East Pye Solar
Statement of Common Ground:
Norfolk County Council

Revision 1
October 2026

Planning Inspectorate Reference: EN0110014
Document Reference: EN0110014/9.4
Rule 8(1)(e) Infrastructure Planning (Examination Procedure) Rules 2010

Sources: Esri, TomTom, Garmin, FAO, NOAA, USGS, © OpenStreetMap contributors, and the GIS User Community

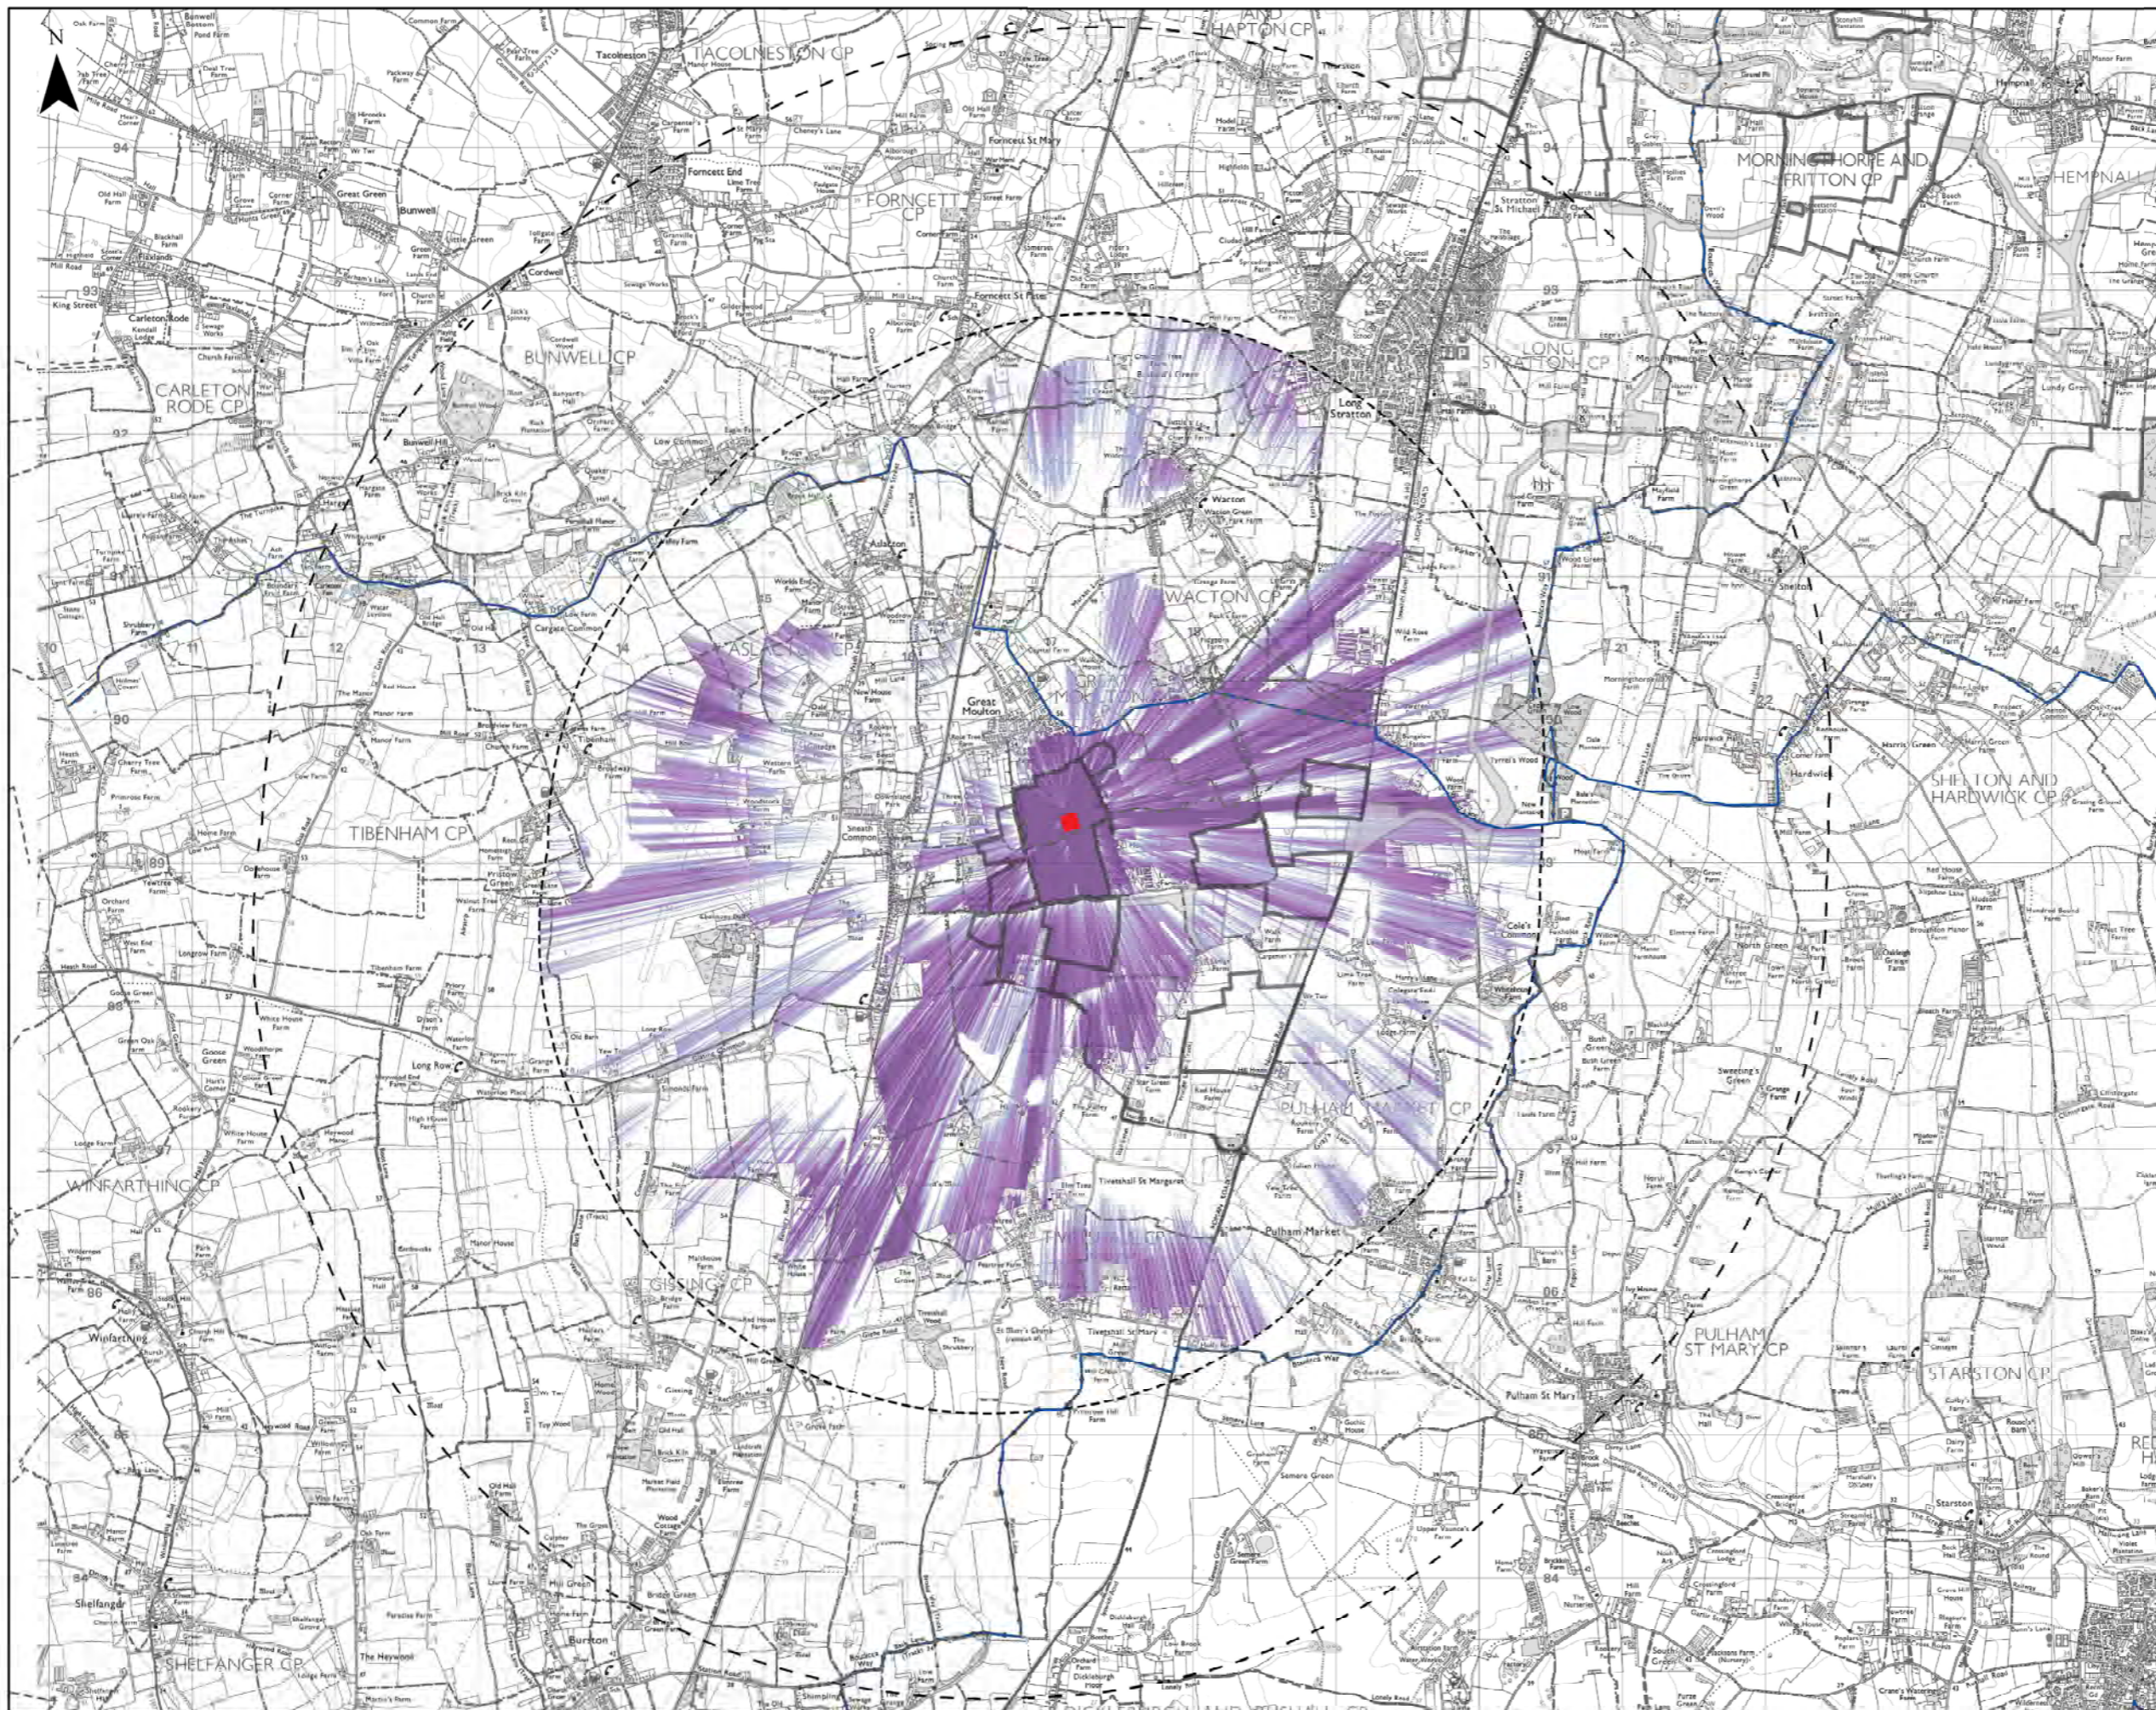
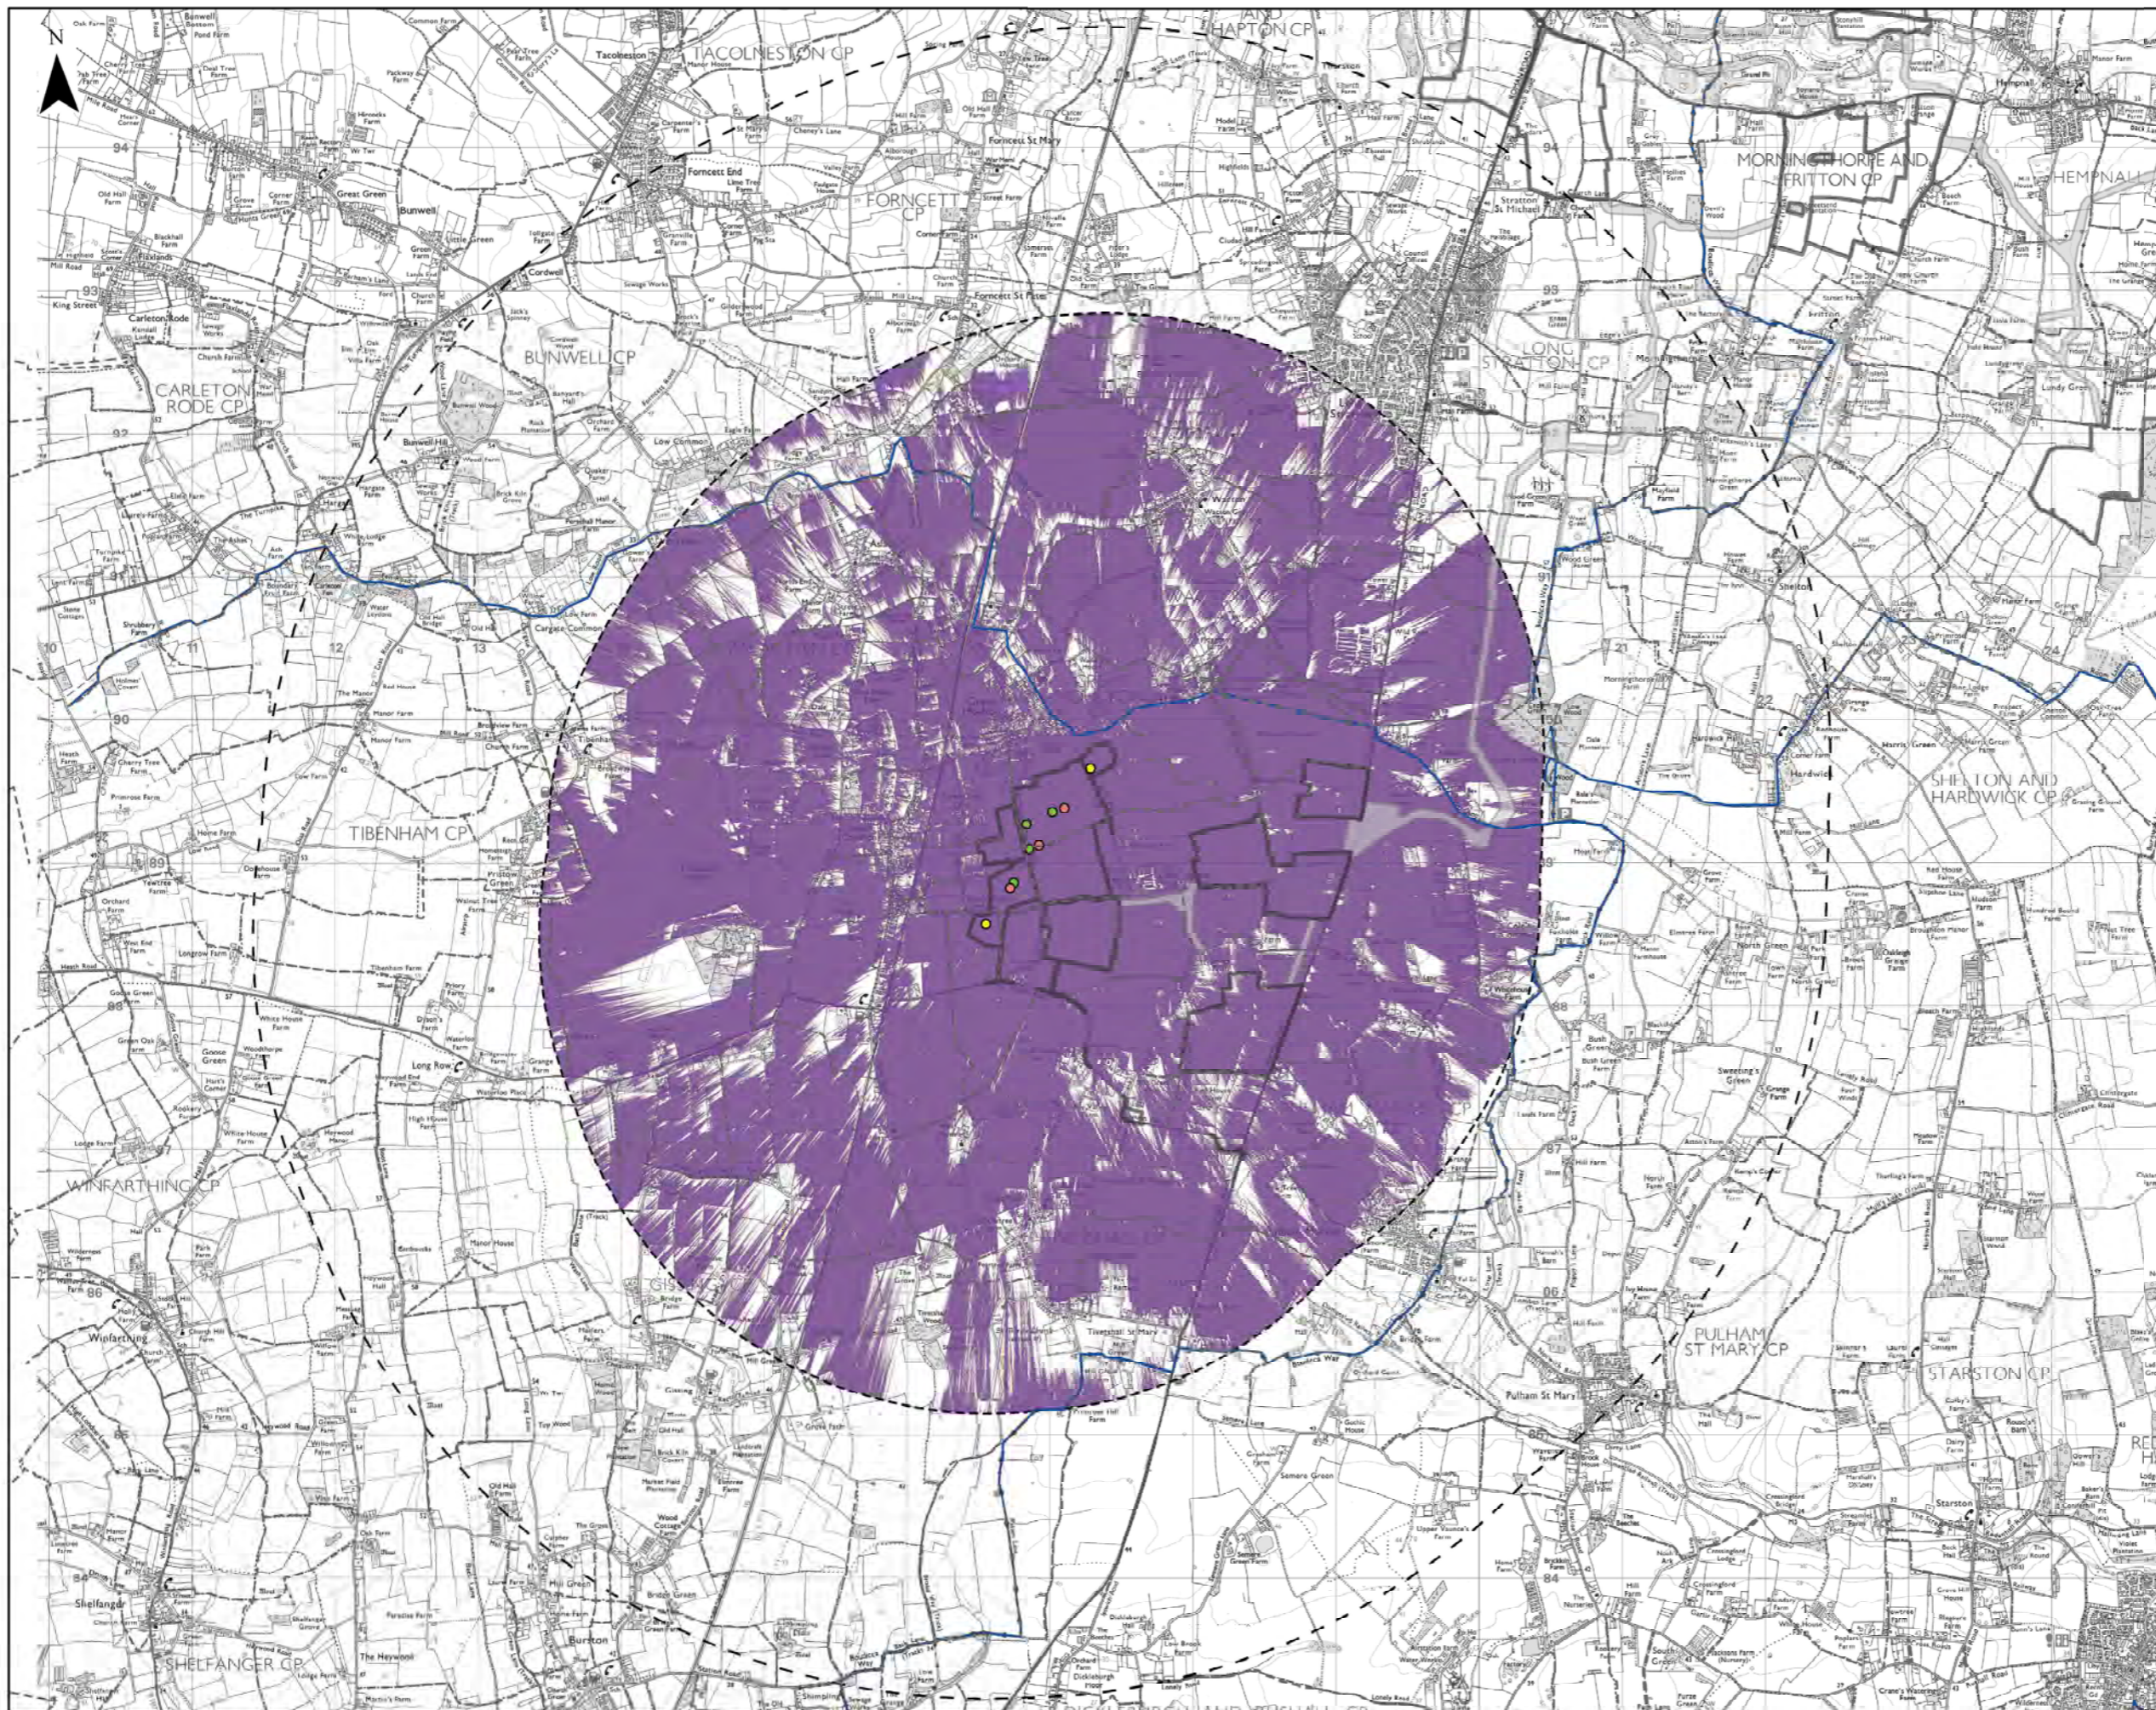
NCC LV – 5	Scope Landscape Character Assessments	ES Volume 1, Chapter 7 - Landscape and Visual [APP-043] ES Volume 3, Appendix 7.2 – Landscape Baseline [APP-119] ES Volume 2, Figure 7.2 - Landscape Character Plan [APP-067]	NCC has reviewed ES Chapter 7 [APP-043] alongside the supporting appendices. The LVIA follows industry standard guidance, including GLVIA3 (Guidelines for Landscape and Visual Impact Assessment) and relevant technical notes.	The published landscape character assessments that are relied upon at the national, regional, and local level and set out within ES Volume 1, Chapter 7 - Landscape and Visual [APP-043] and ES Volume 3, Appendix 7.2 - Landscape Baseline [APP-119] and ES Volume 2, Figure 7.2 - Landscape Character Plan [APP-067] are considered acceptable to inform the assessment baseline conditions.	Under Discussion
NCC LV – 6	Scheme design Concerns about new overhead lines/pylons as part of grid connection – suggest that grid connection cabling undergrounded and no new pylons.	ES Volume 1, Chapter 4 - The Scheme [APP-040] ES Volume 2, Figure 7.5.10 - Site 1 Zone of Theoretical Visibility [APP-079] ES Volume 2, Appendix 7.7 - Visual Assessment Tables [APP-147]	NCC is concerned the new overhead lines and pylons will have wider visual impact and will have disruption during construction. NCC suggested used of underground cables where possible to connect to the existing 400kV line.	The Applicant has sought to minimise the effect and extent for new overhead cables with siting of the National Grid Substation in close proximity to the existing 400kV line. Grid connection infrastructure will nevertheless be required between the National Grid Substation and the existing 400 kV overhead line (Norwich Main – Bramford). The final design of the substation is ultimately at National Grid's discretion. As such, the Applicant has assessed a reasonable worse case scenario in which the connection from the National Grid substation and the NETS was assessed as using overhead lines, as opposed to underground cables. The Scheme proposes to divert the existing 400 kV overhead line into a newly constructed National Grid Substation. ES Volume 1, Chapter 4 - The Scheme [APP-040] describes the proposed works in relation to the grid connection and proposed pylons.	Under Discussion

Reference	Matter Topic	Document Reference of Matters	Consultee Position	Applicant's Position	Status
				A comparative ZTV is produced as part of ES Volume 2, Figure 7.5.10 - Site 1 Zone of Theoretical Visibility [AS-007] . The Applicant considers the visibility of the additional pylon is similar to the baseline. Where the proposed additional pylon has the potential to influence visual amenity, this has been assessed within ES Volume 2, Appendix 7.7 - Visual Assessment Tables [APP-147] .	
NCC LV – 7	Scheme design Favoured national grid Substation option further away from Great Moulton	Site Selection Assessment [APP-215]	The consultee favoured the option with the National Grid Substation further away from Great Moulton.	The Site Selection Assessment [APP-215] explains the rationale for why the National Grid Substation has been located at Site 1b.	Not Agreed
NCC LV – 8	Scheme design Concern about the upgrade of the 132 kV substation south of Great Moulton to 400kV which will have a greater visual impact.	ES Volume 1, Chapter 7 - Landscape and Visual [APP-043]	The consultee is concerned about the upgrade of the 132 kV substation south of Great Moulton to 400kV which will have a greater visual impact.	The visual effects of the 400kV Project Sub-Station adjacent to the proposed National Grid substation south of Great Moulton has been assessed within ES Volume 1, Chapter 7 - Landscape and Visual [APP-043]. As set out in the Site Selection Assessment [APP-215], the chosen location for the National Grid Substation avoids major designated areas of ecological or cultural importance, with only limited priority habitats and no heritage assets, County Wildlife Sites or Ancient Woodland present. The National Grid Substation and overhead lines would therefore avoid areas of high amenity, cultural, and scientific value in line with the Holford / Horlock Rules and NPS EN-5. As part of the design evolution, the National Grid Substation was also reorientated north south to enable greater opportunities of screening from existing vegetation to the north to reduce the visibility from Great Moulton and provide a greater offset from Narrowgate Way PRow demonstrating that landscape and visual effects have been minimised through iterative design. NPS EN-1 states at para 5.10.5 that ‘<i>Virtually all nationally significant energy infrastructure projects will have adverse effects on the landscape</i>’, and at para 5.10.13 that ‘<i>All proposed energy infrastructure is likely to have visual effects for many receptors around proposed sites</i>’. Due to the scale of the proposed infrastructure in Site 1, the Applicant identifies change to some of the key characteristics and visual amenity of Site 1	Under Discussion
